From: Jeff Smith <Jeffrey.Smith@endeavourenergy.com.au>
Sent: Thursday, 8 July 2021 9:30 AM
To: Grant Harlow
Subject: RE: S29/3/97-Mod-1 - Eastern Creek Karts, Departments design comments

Subject: S29/3/97-Mod-1 - Eastern Creek Karts, Departments design comments

Following on from our discussions on design requirements on 26th and 28th May 2021 for the above please see the following notes for design work :-

PLAN:
SHOWING CATENARY 1
AT SYDNEY PREMIERE KART PARK
BEING LOT 4 IN DP 1079897

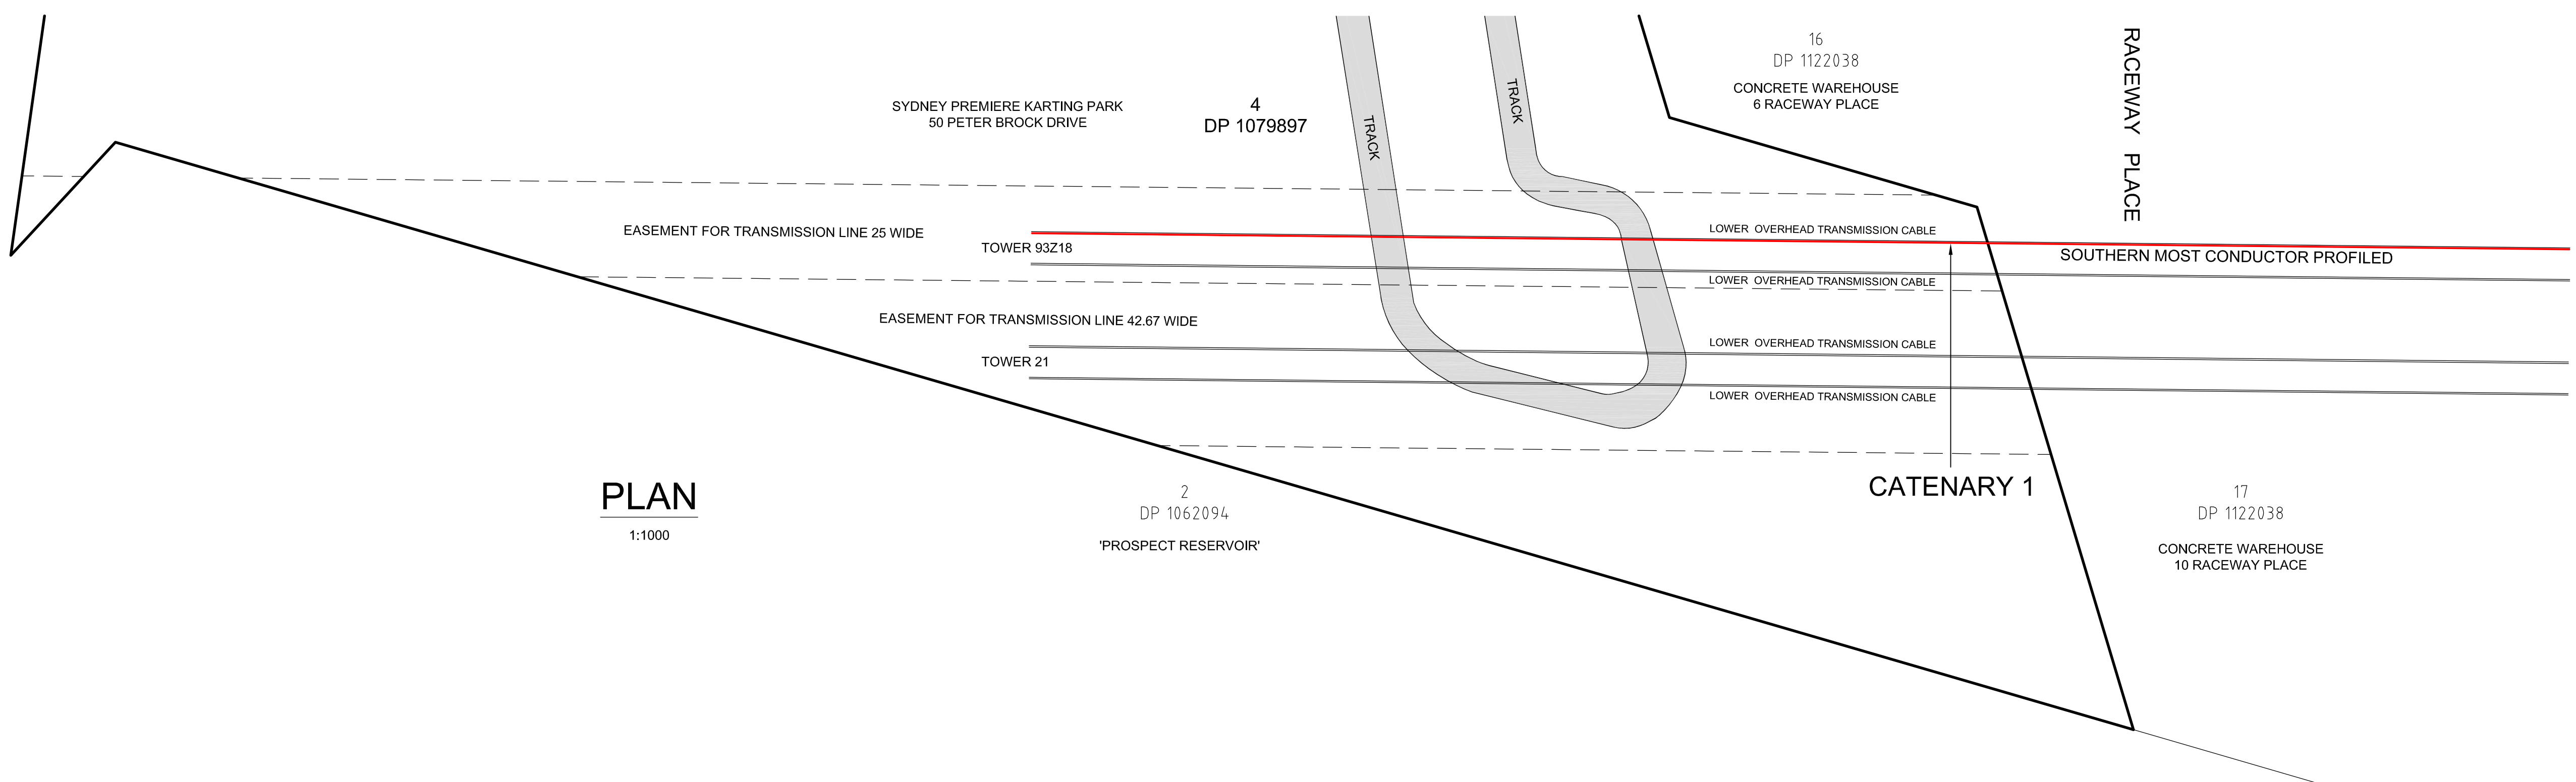
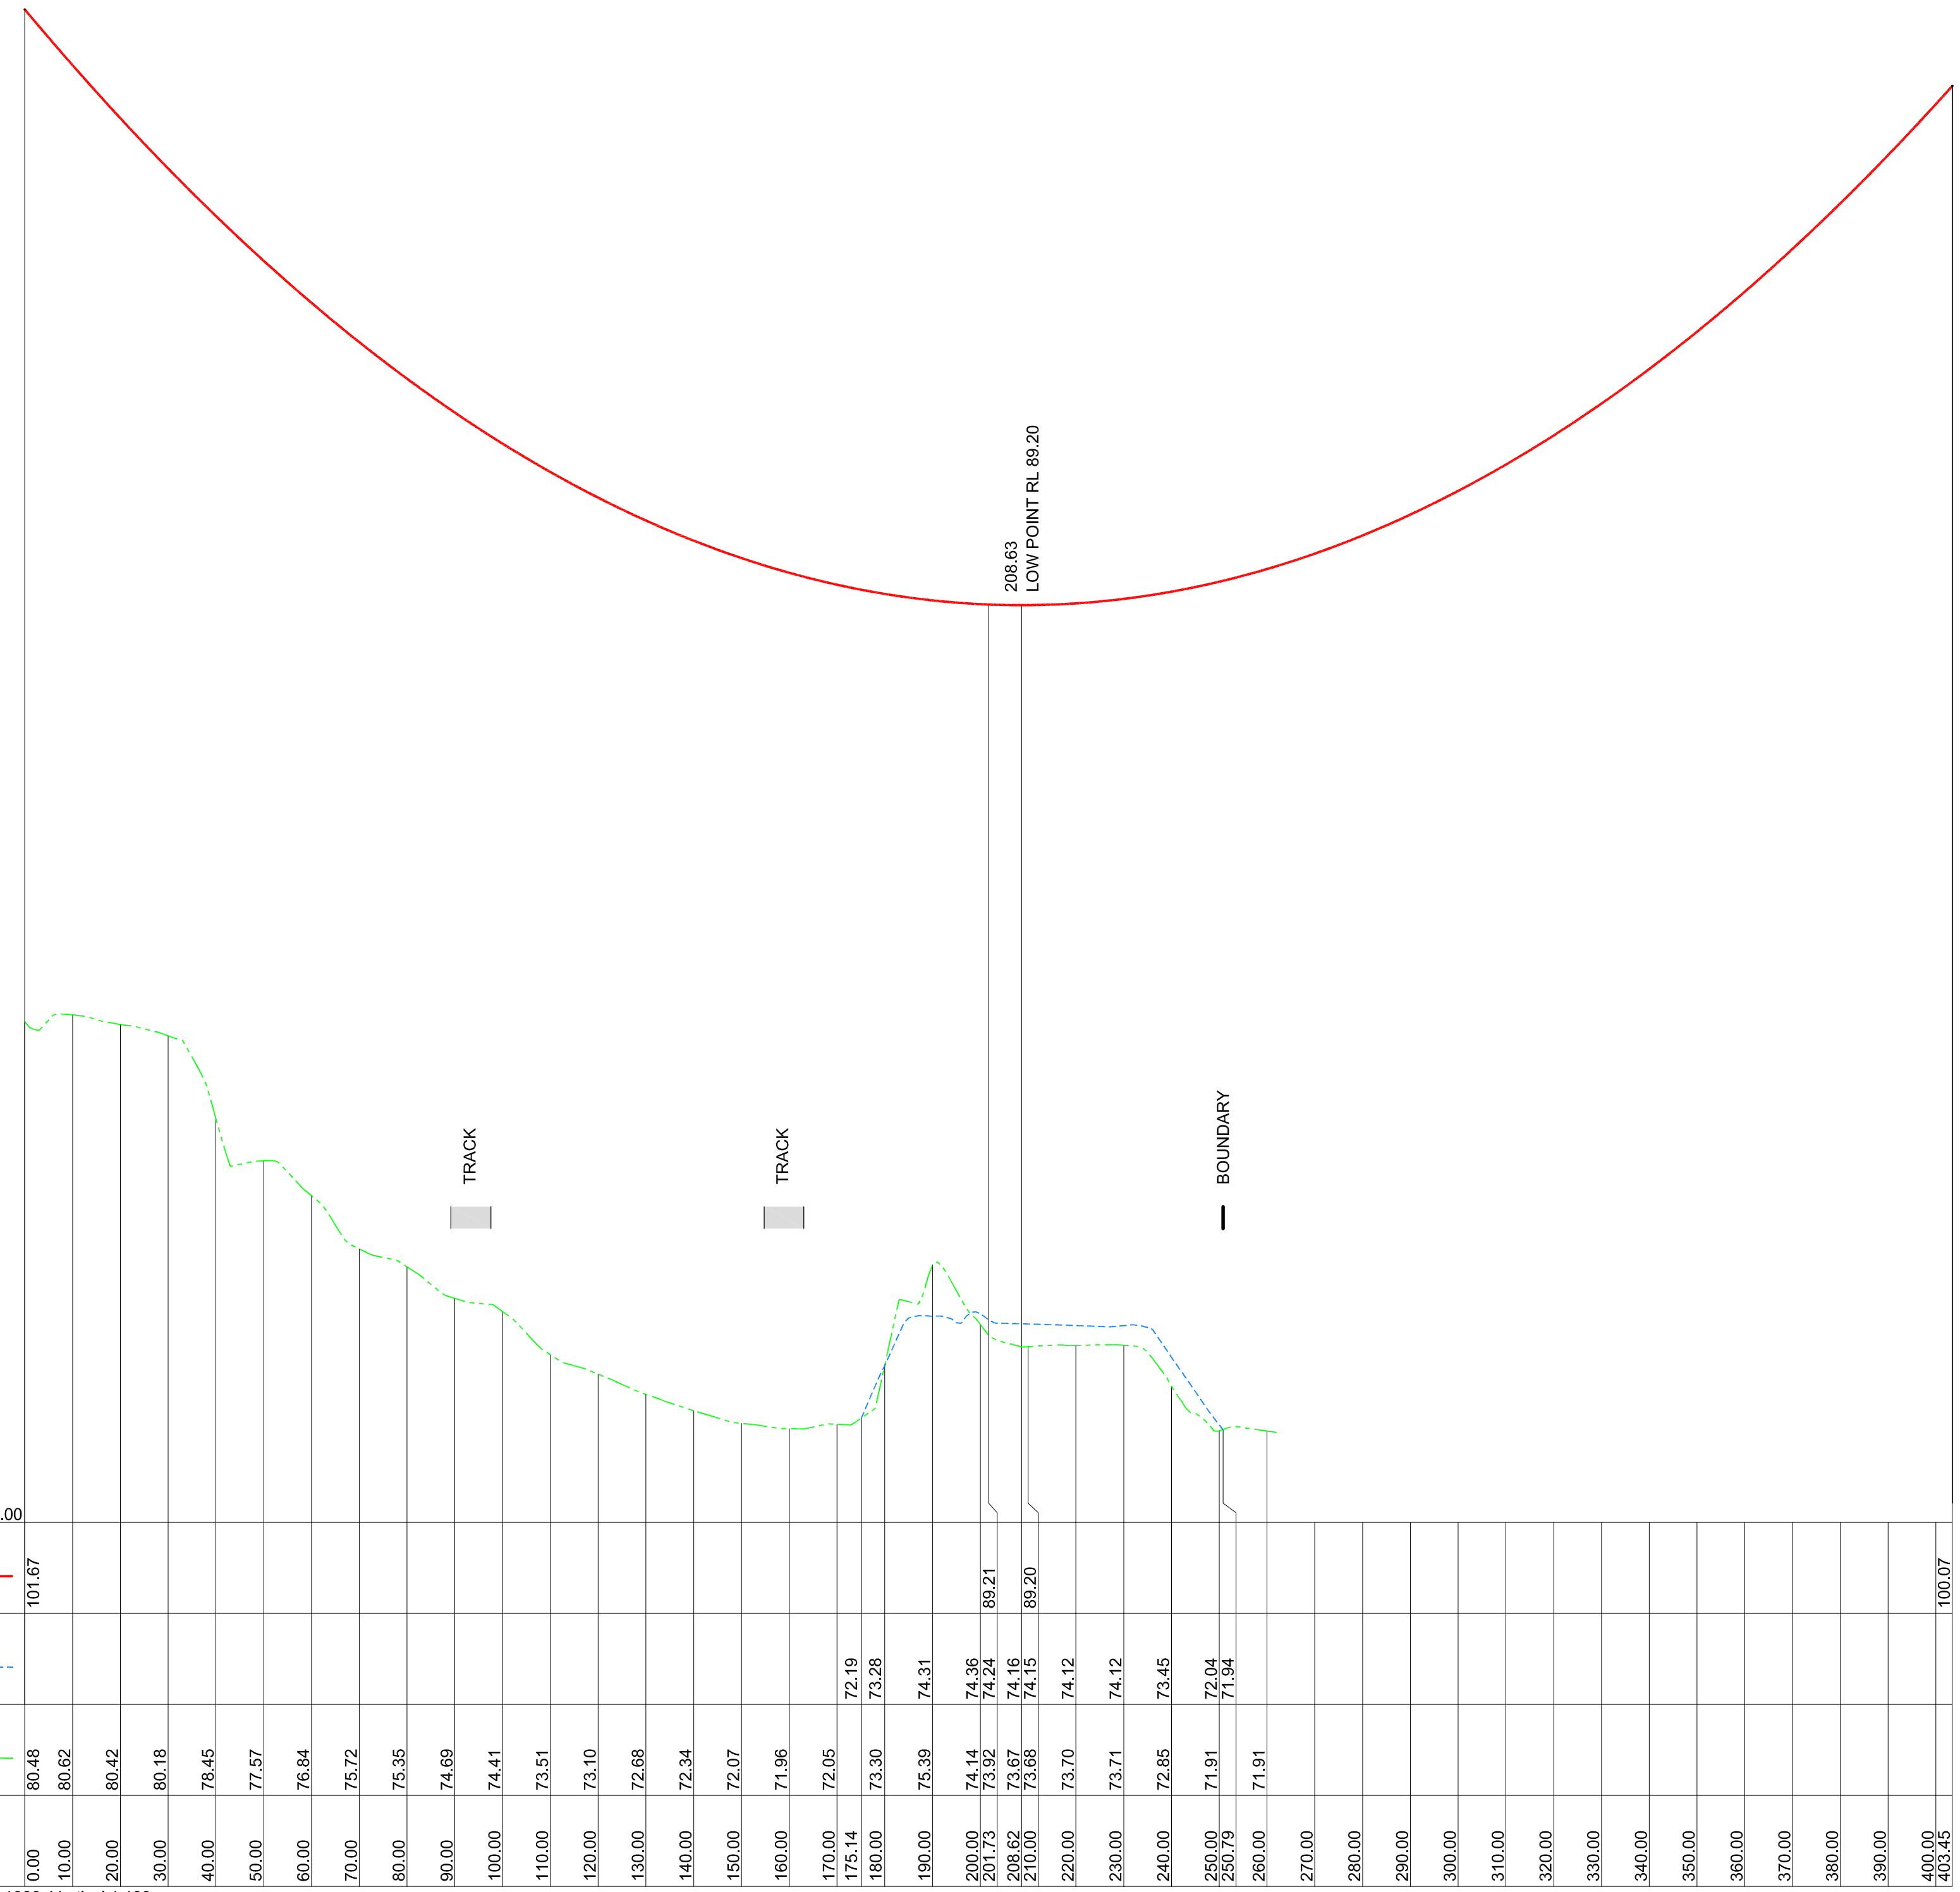
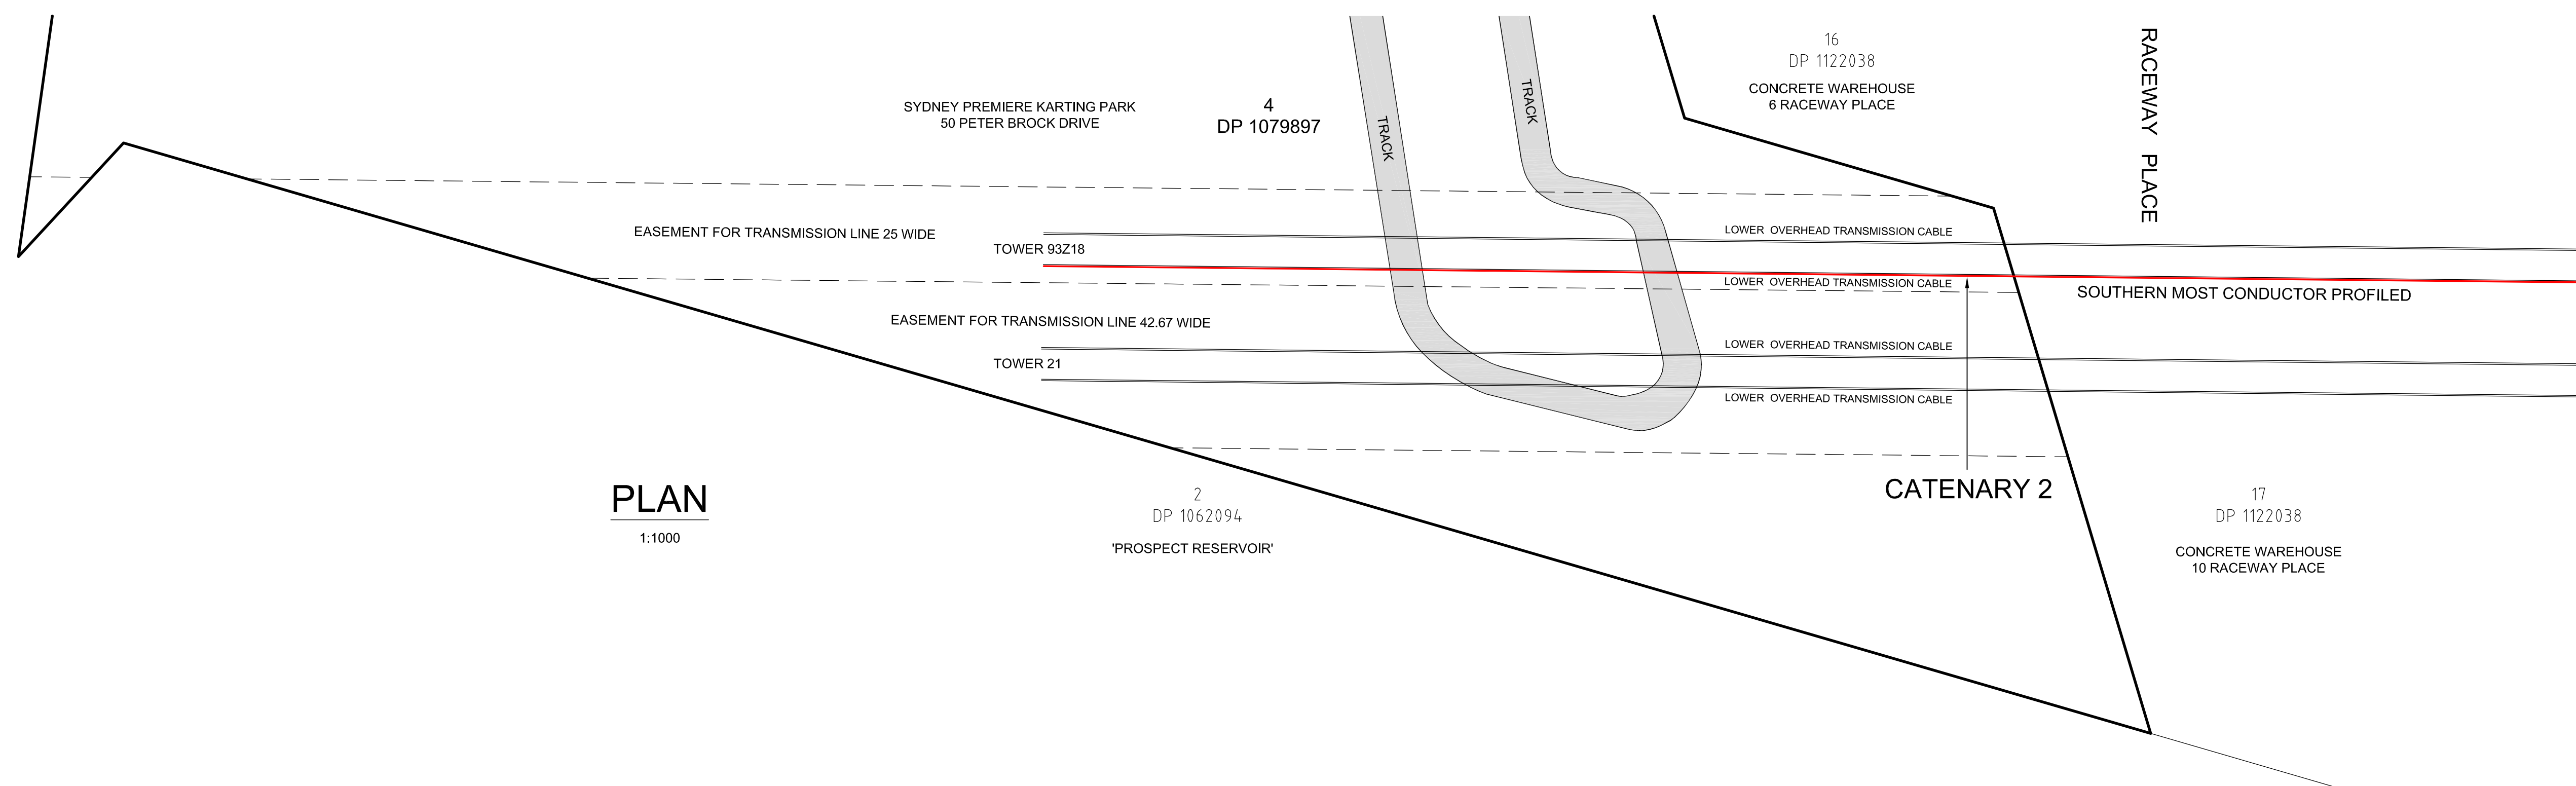
- 1) An updated Centre-Line Profile including current levels and the proposed Levels.
- 2) The 132kv Earth Potential Rise Assessment Report.

- A Centre-Line Profile, as per the requirements stipulated within *clause 6* of the General Restrictions for Overhead Power Lines.
This must include the Current Levels and the Proposed Levels.
- A 132,000 volt Earth Potential Rise Assessment Report as described in the *Electrical Hazards in Pipeline Construction* attachments.

I note that we have made some slight adjustments to the proposed carpark surface mainly for drainage reasons. These are minor and do not result in any material change to the centreline profiles previous supplied. We will however provide you with an updated set of profiles.
